Re: Fuentes Auto Sales
700 Gibson Blvd. SE
Traffic Circulation Layout
Engineer's/Architect's Stamp XX-XX-XX (L14-D010)

PROPOSED SITE PLAN  
SCALE: 1"=20'

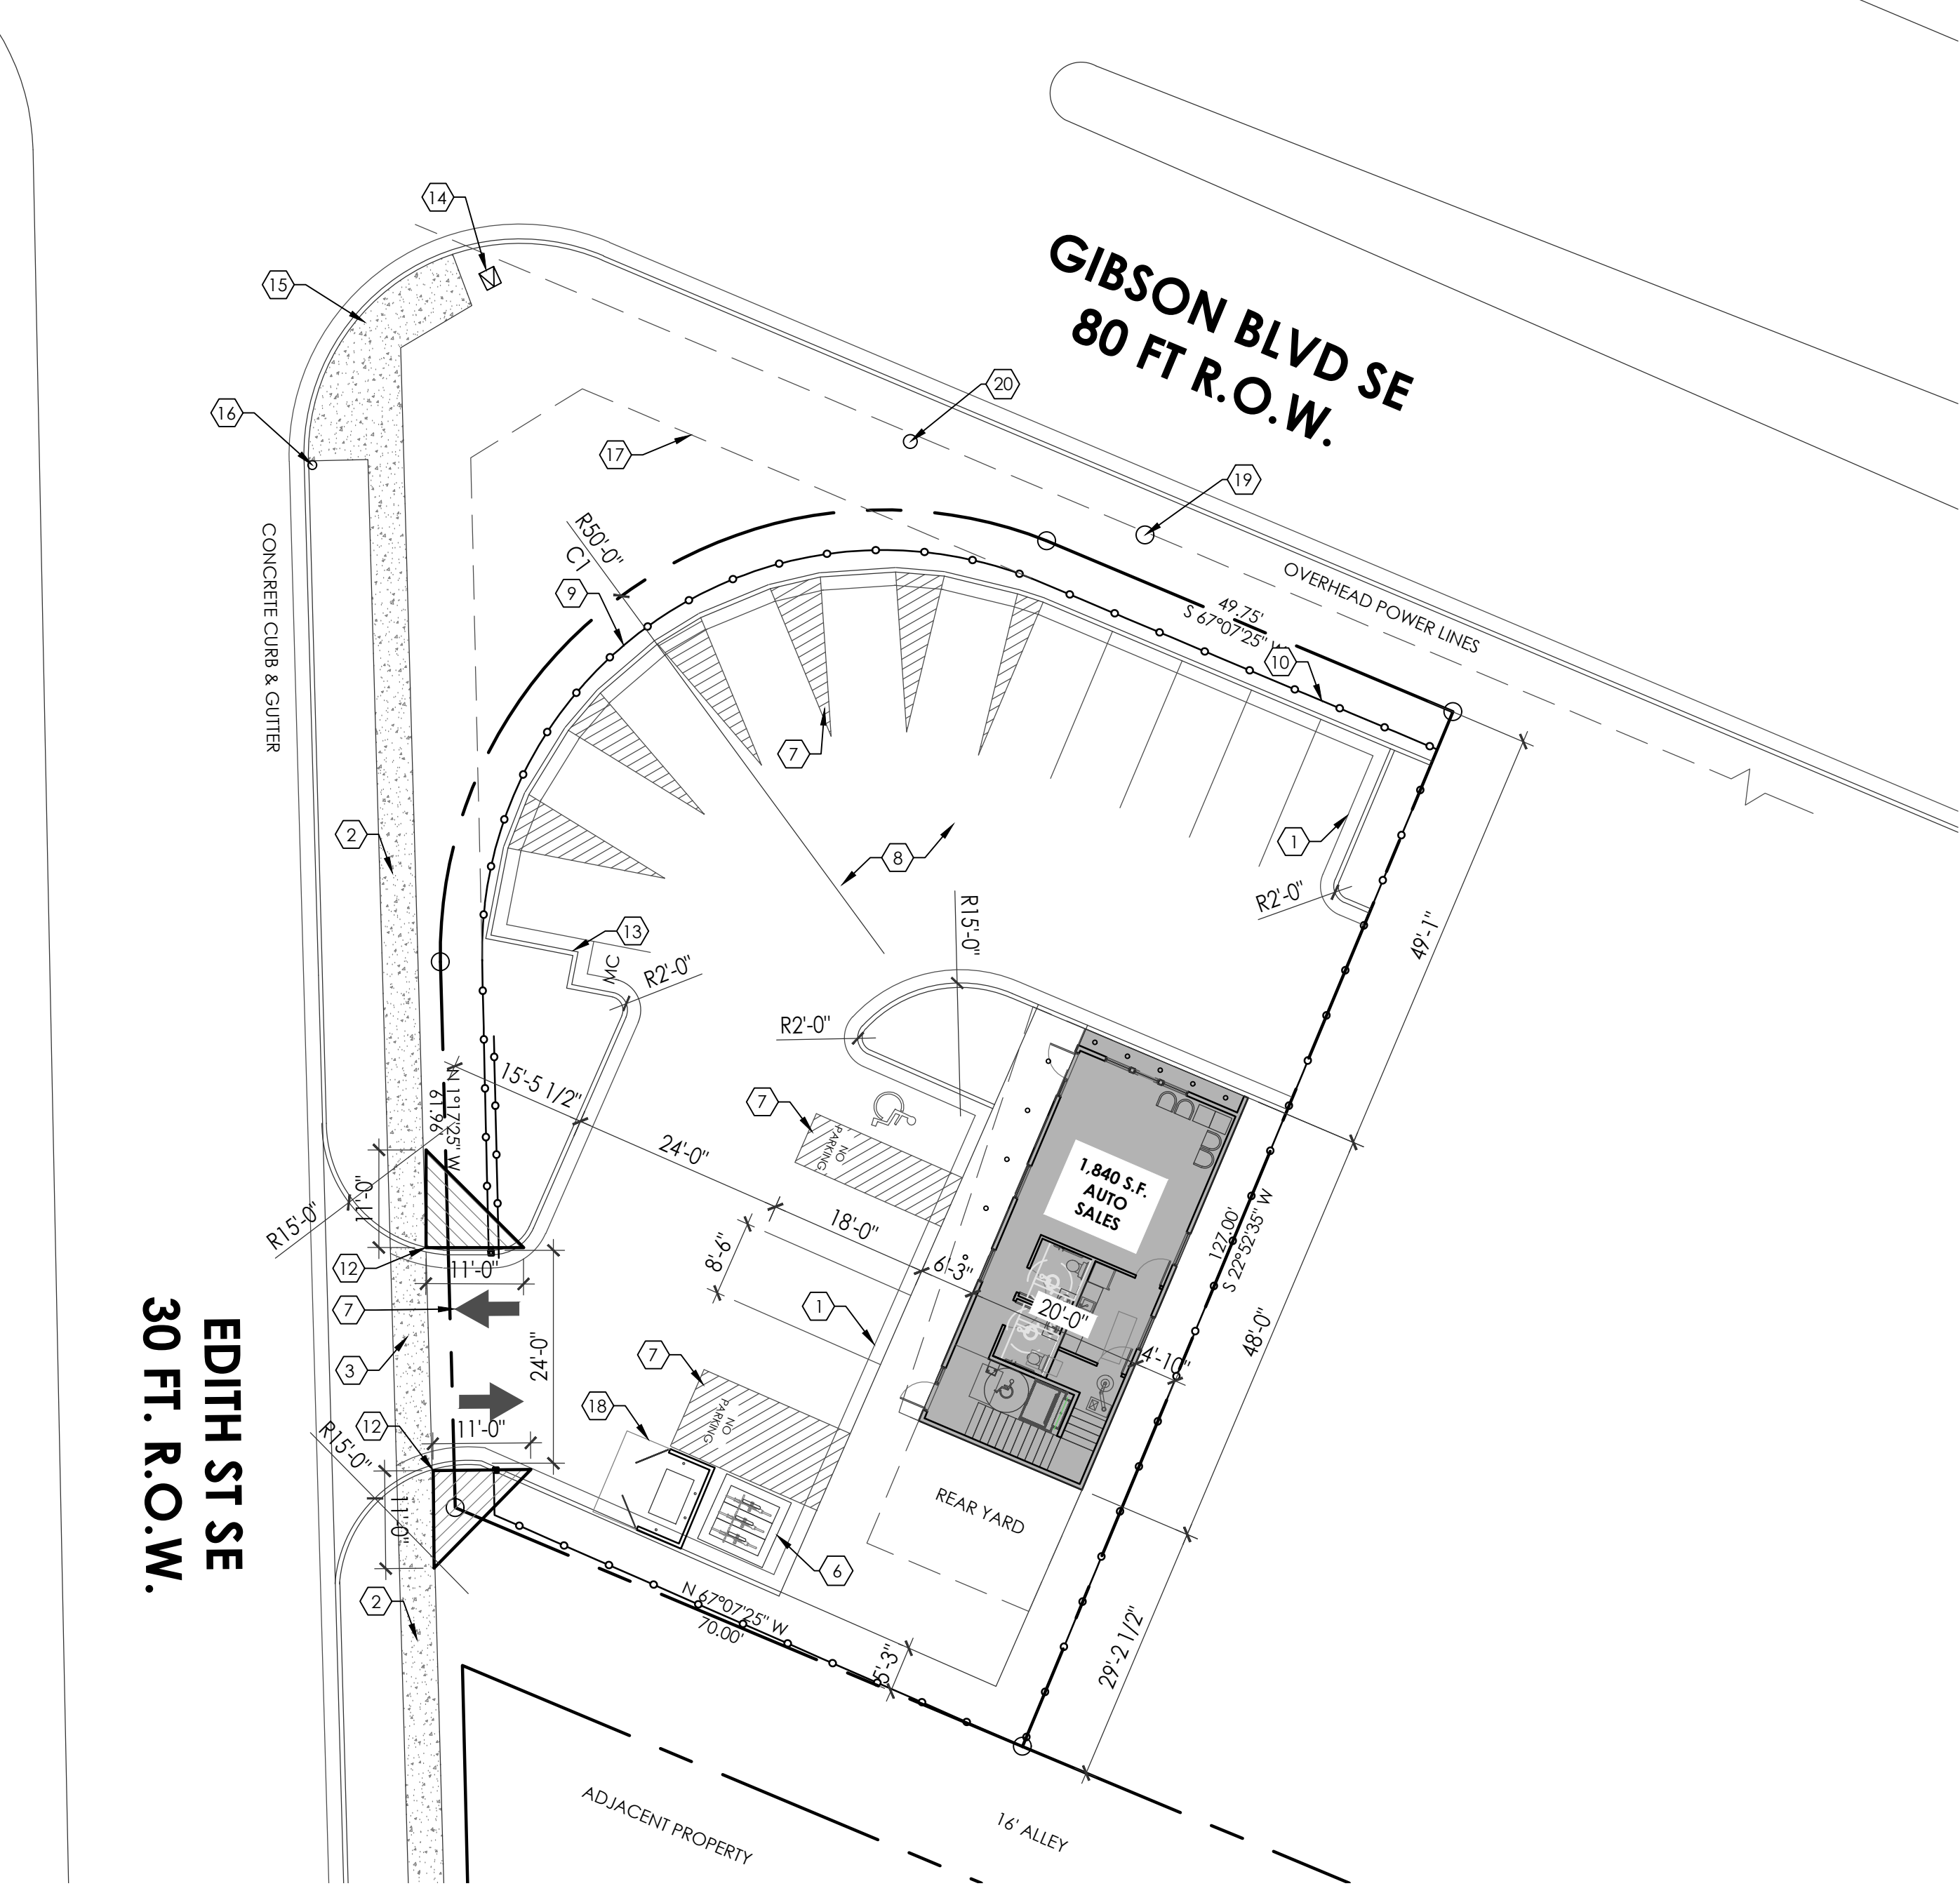
2. 6 ft. wide sidewalk must be built along Gibson Blvd. from property line to property line. For sidewalk waiver, please contact Ernest Armijo earmijo@cabq.gov
Drawings now show new city sidewalk

3. Minimum distance from the commercial site access to the intersection is 75 ft. please show this dimension on the site plan. **Drawings show the dimension from intersection.**

4. Please provide ADA ramps at the proposed site access or reference COA std dwg.
Drawings now show ADA ramps per COA stds.
5. ADA curb ramp at the corner of Gibson Blvd. and Edith St. must be updated to current standards and has truncated domes installed. **Drawings now show updated ADA ramp**

6. Identify all existing access easements and rights of way width dimensions.
Drawings show dimensions of roadway easements
7. Please list the width and length for all existing and proposed parking spaces. Some dimensions are not shown. **Drawings now dimension all parking spaces**

9. The ADA accessible spaces must include an access aisle. Van accessible aisles should be 8ft wide; all others should be 5ft wide. **Drawings show the access aisle**

10. Per the IDO, a 6 ft. wide ADA accessible pedestrian pathway is required from the public sidewalk to the building entrances. Please clearly show this pathway and provide details. Drawings now include accessible pedestrian pathway

11. Per DPM, a 6 ft. wide ADA accessible pedestrian pathway is required from the ADA parking stall access aisles to the building entrances. Please clearly show this pathway and provide details. Drawings show the pedestrian pathway

12. ADA accessible pedestrian pathway should not be placed behind parking space or adjacent to a vehicular way. Vehicle and pedestrian/wheel chair conflicts should be avoided as much as possible. Drawings show the pedestrian pathway

**E** REFUSE ENCLOSURE - PLAN AND SECTION  
SCALE: 1/4"=1'-0"

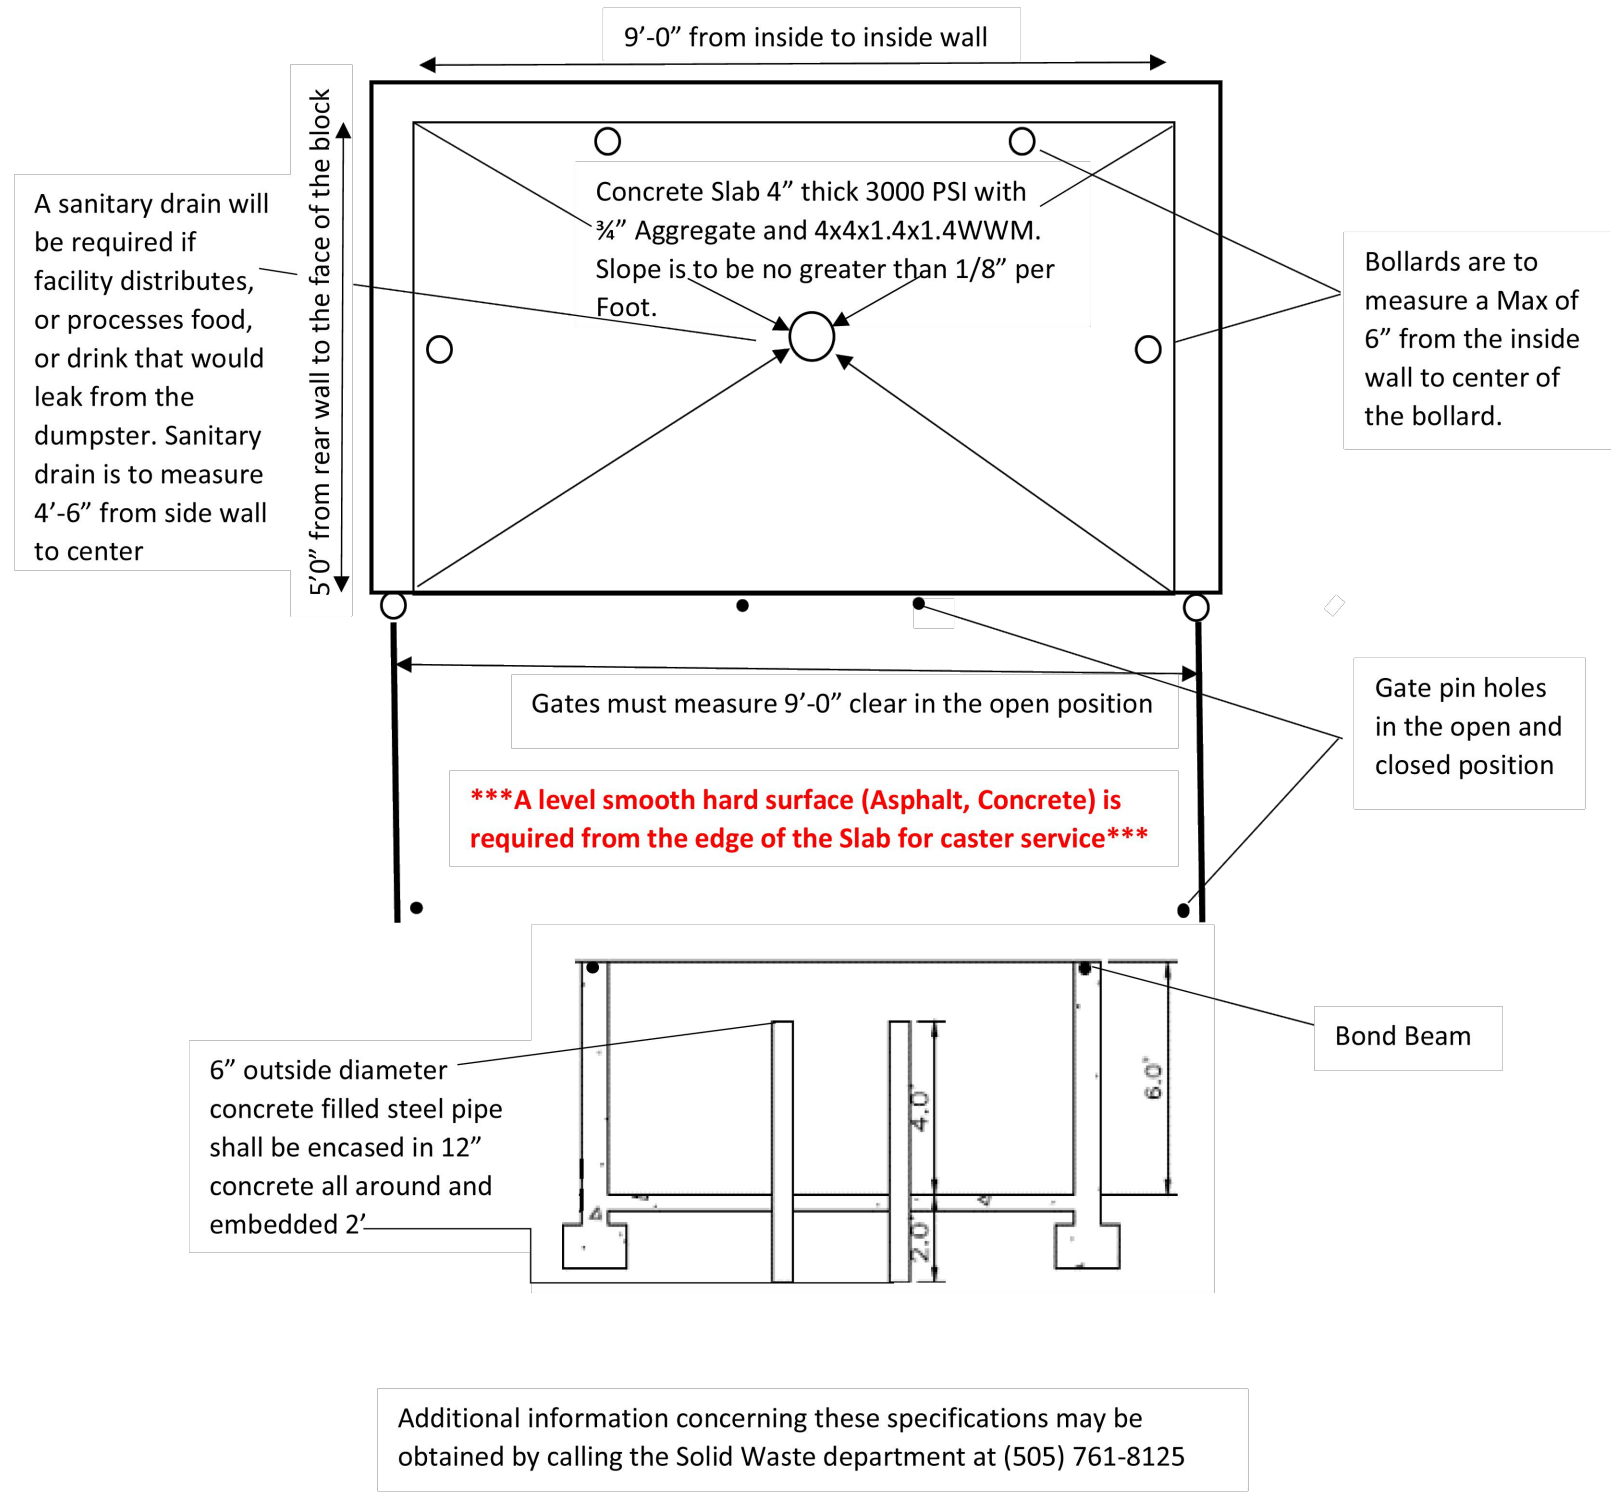
13. Please remove trash enclosure details from TCL-2. Details have been removed
14. Provide a copy of Fire Marshal and Solid Waste approval. Approved drawings included
